STATEMENT OF COMMON GROUND WITH CANAL & RIVER TRUST

HyNet Carbon Dioxide Pipeline DCO

Document Reference Number D.7.2.11

Applicant: Liverpool Bay CCS Limited

DRAWING NUMBER
EN070007-APP-ES-18.4.13

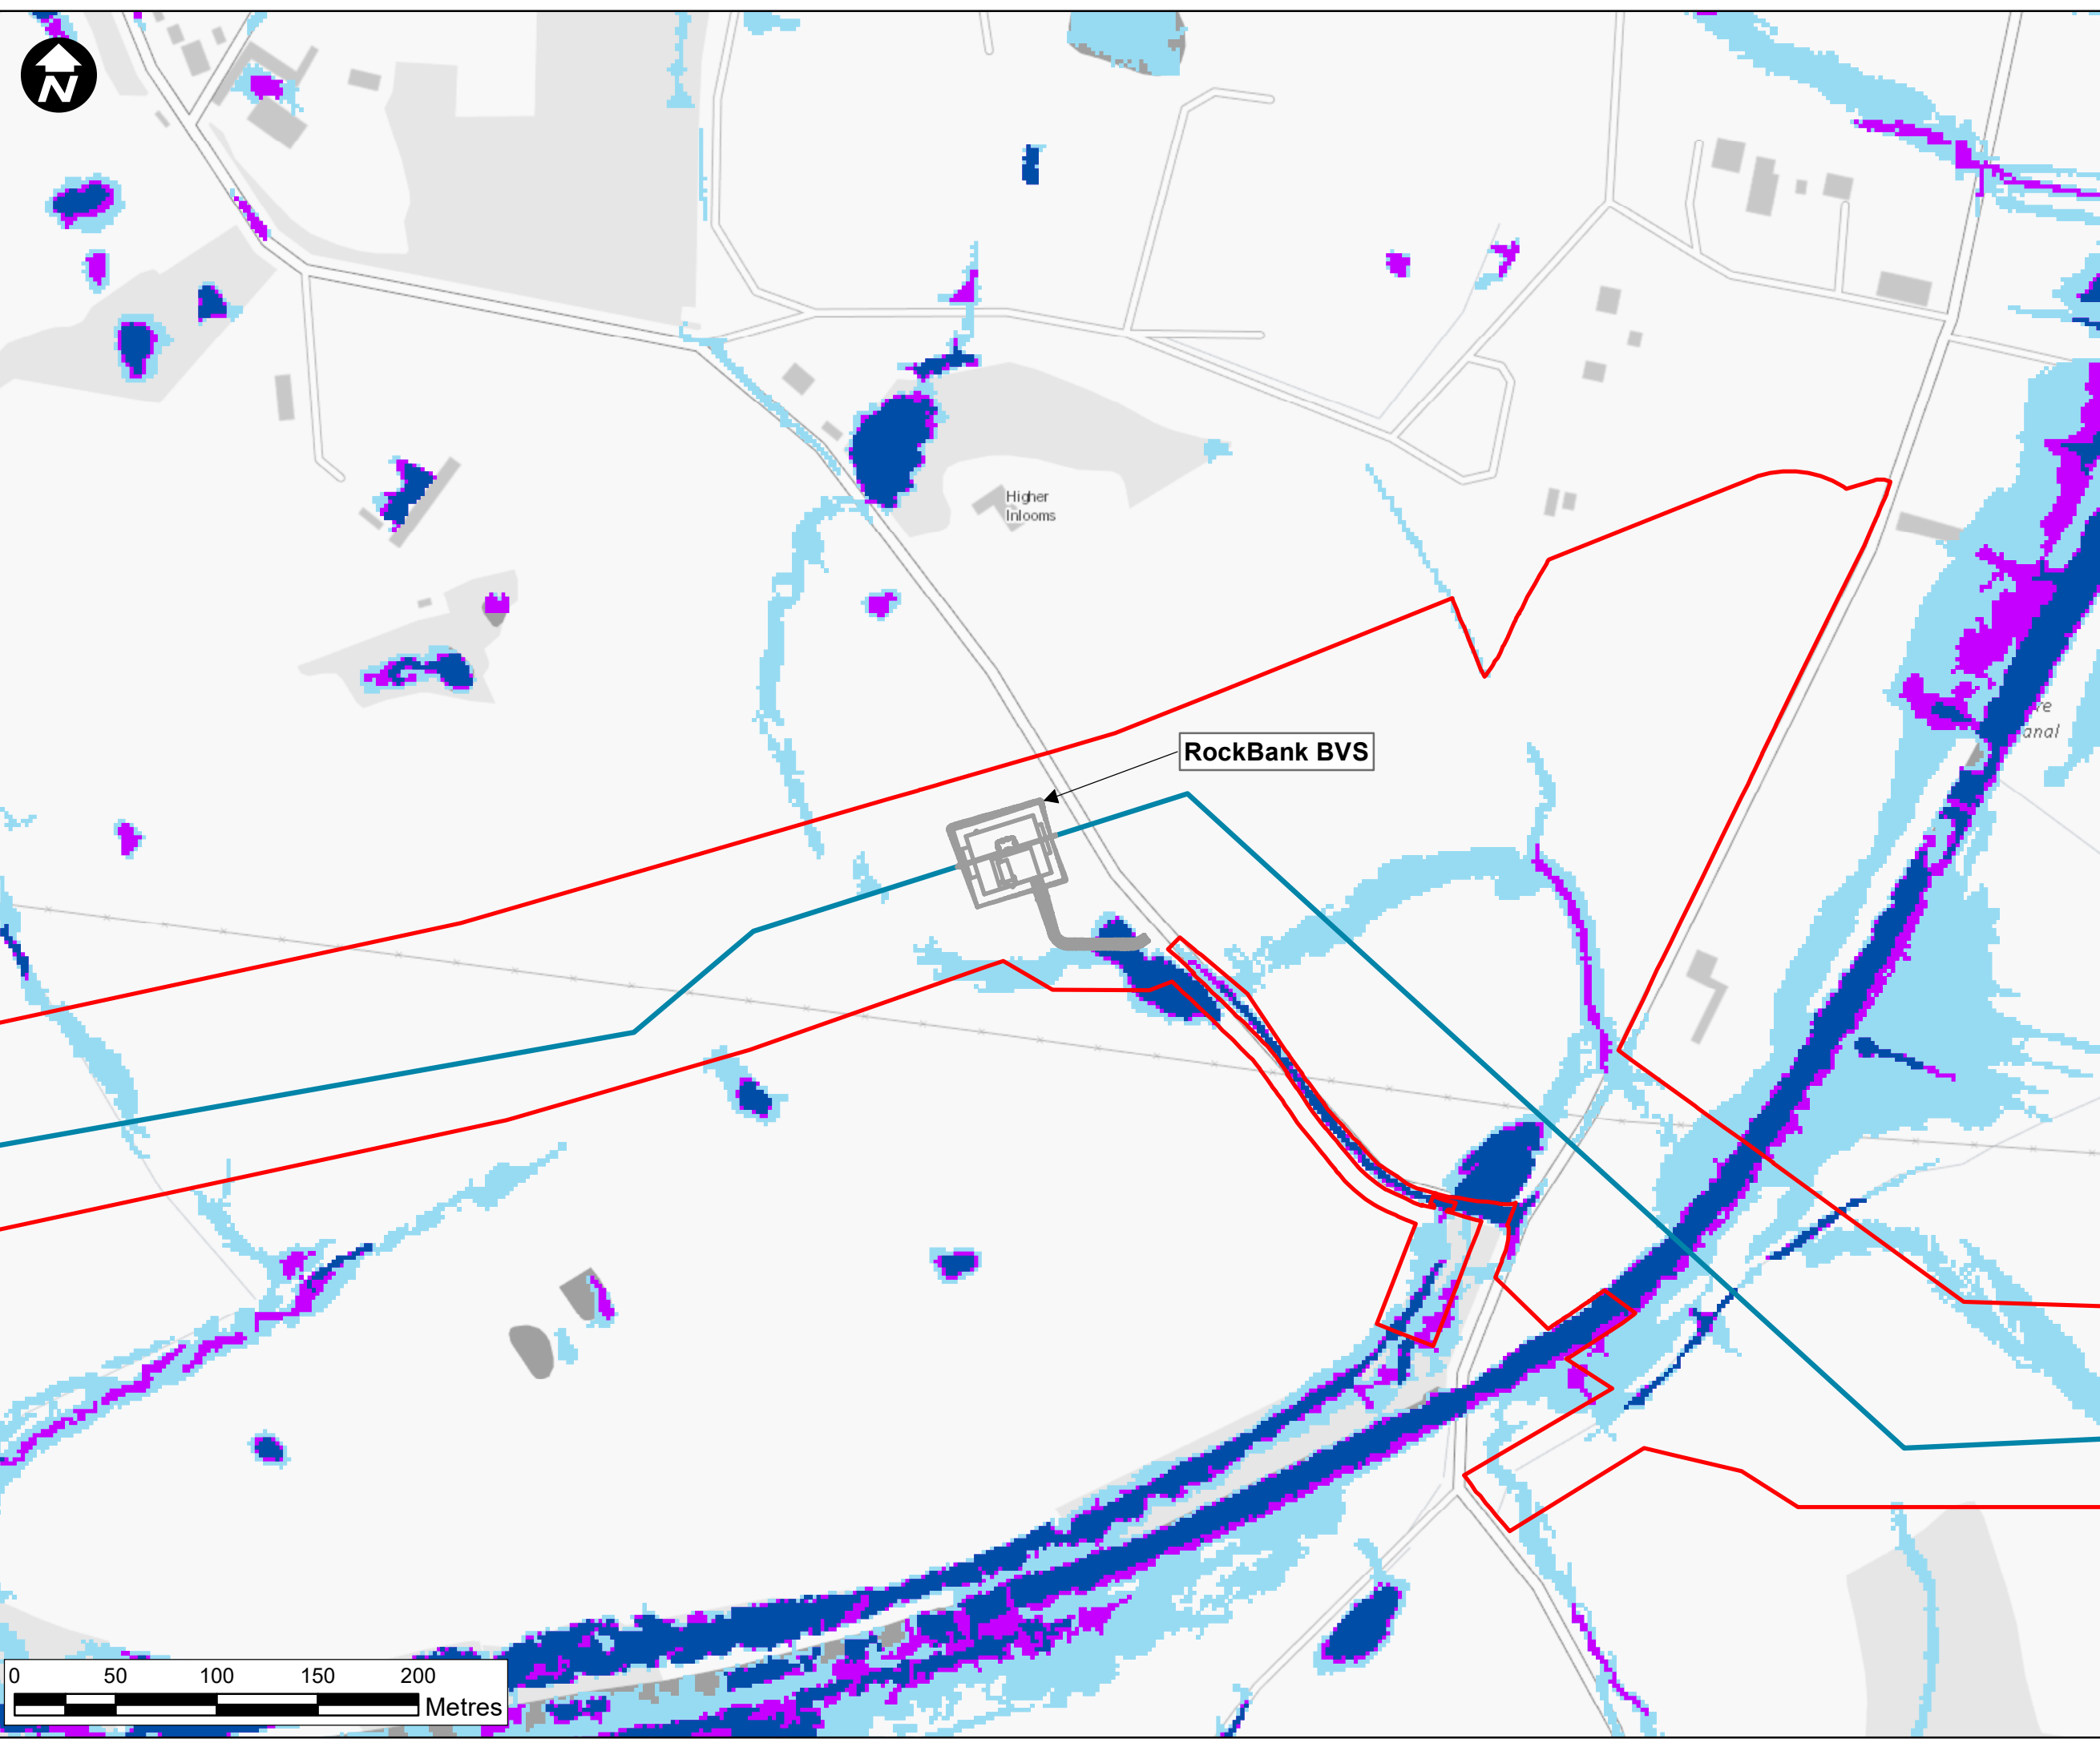
Trust 3.7.3	Drainage for Rock Bank BVS	<p>The Trust has raised a concern that the drainage arrangements for Rock Bank BVS appear to connect to a ‘canal ditch,’ which appears to have an outfall to the canal next to bridge 134. If this is the case, then the surface water discharge would need to be reviewed and a discharge licence will be needed. The Applicant acknowledges the note above at 3.7.2 in relation to drainage into the canal. This will be reviewed further at the detailed design stage (currently only at strategy status), and if drainage is required, the SWD process (via the Trust’s Third-Party Code of Practice) would apply. The Applicant will also review the need for a discharge licence, should any discharge to canal assets be required.</p>	Agreed

**VIEWPOINT P13a - Shropshire Union Canal Towpath, nr Liverpool Road, Backford**

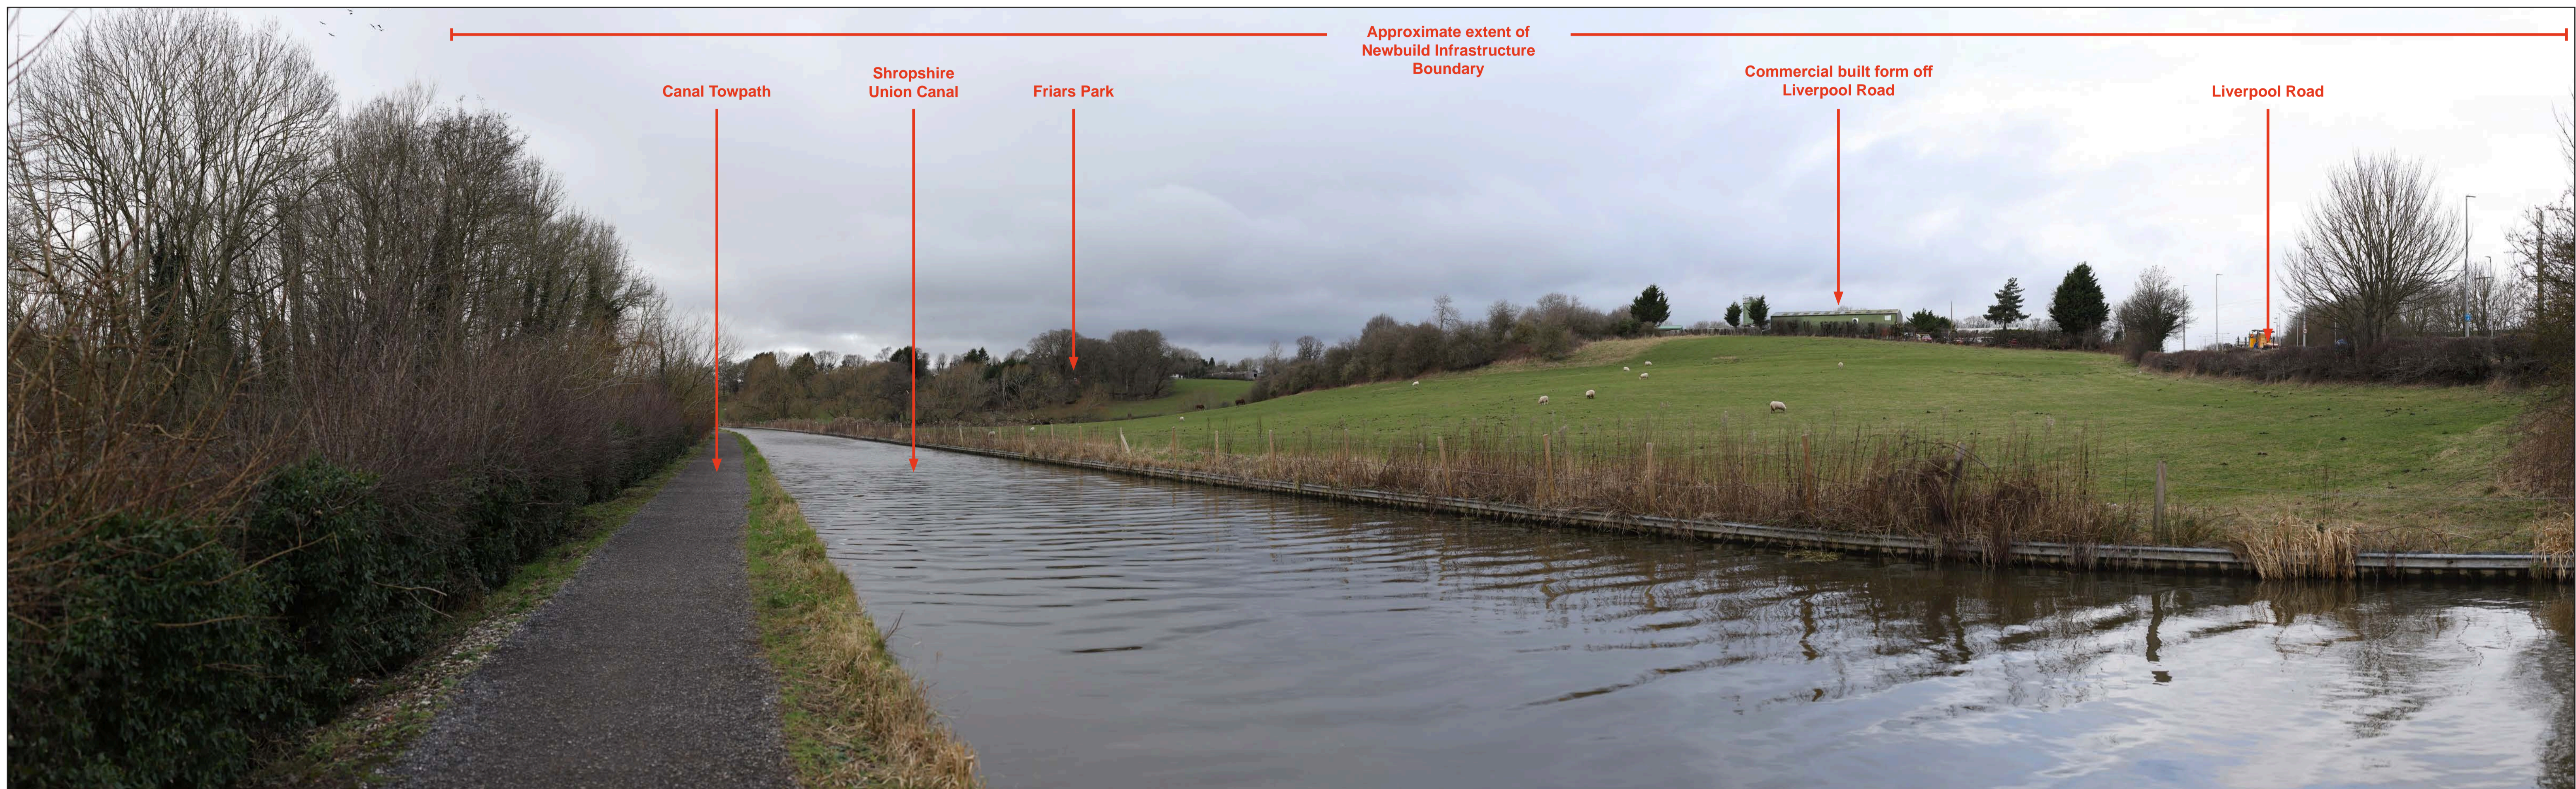
Ref.	Description of Matter	Current Position	Status
Trust 3.2.1	Viewpoints	Initial viewpoint locations were issued to the Trust and the majority of these were approved. Two additional viewpoint locations along the Shropshire Union Canal, were requested by the Trust. Additional photography has been undertaken and these viewpoints are now included within the assessment. The viewpoints are now approved, and the Trust is in agreement with the selected locations.	Agreed
Trust 3.2.2	Photomontages	Six photomontage viewpoint locations were submitted to the Trust. In relation to impacts on the canal corridor, the Parties concluded that permanent above ground structures would be set well back from the canal with only temporary effects associated with construction activity likely to be perceived. Therefore, it is considered that there is no requirement for further photomontages to represent views from the canal corridor and that the original photomontage viewpoint locations are agreed.	Agreed
